**From:** Mark Warwick  
**Sent:** 16 November 2018 12:17  
**To:** Simon Davis  
**Subject:** FP/171/18/PL

I refer to my previous comments in respect of this development proposal (19<sup>th</sup> September and 6<sup>th</sup> November) and for the record sustain my OBJECTION in the absence of a satisfactory revision to the site layout/access.

**Arboricultural Impact Assessment and Method Statement, Report Ref: PR121588aia-ams and Tree Protection Plan ref: PR121588-03.**

scheme: Land West of Stanhorn Grove
Felpham
client: Worthing Homes
drawing: Tree Protection Plan
date: October 2018
scale: 1:200@A1
dwg no: PRI21588-03
drawn: RA checked: MW

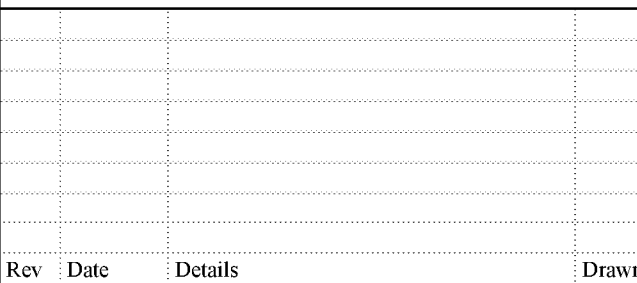
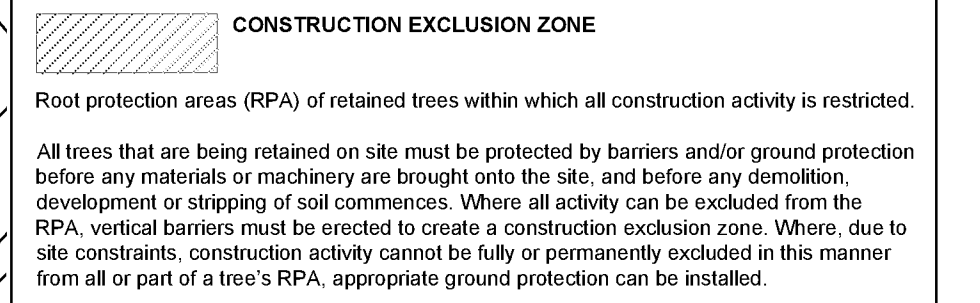
**Prior to applying the aforementioned conditions, it will be necessary for the applicant to submit for our approval, the precise areas where ground protection measures and 'No-dig' solutions are to be employed and provide a detailed specification for each – then illustrate those areas clearly on the Tree Protection Plan.**
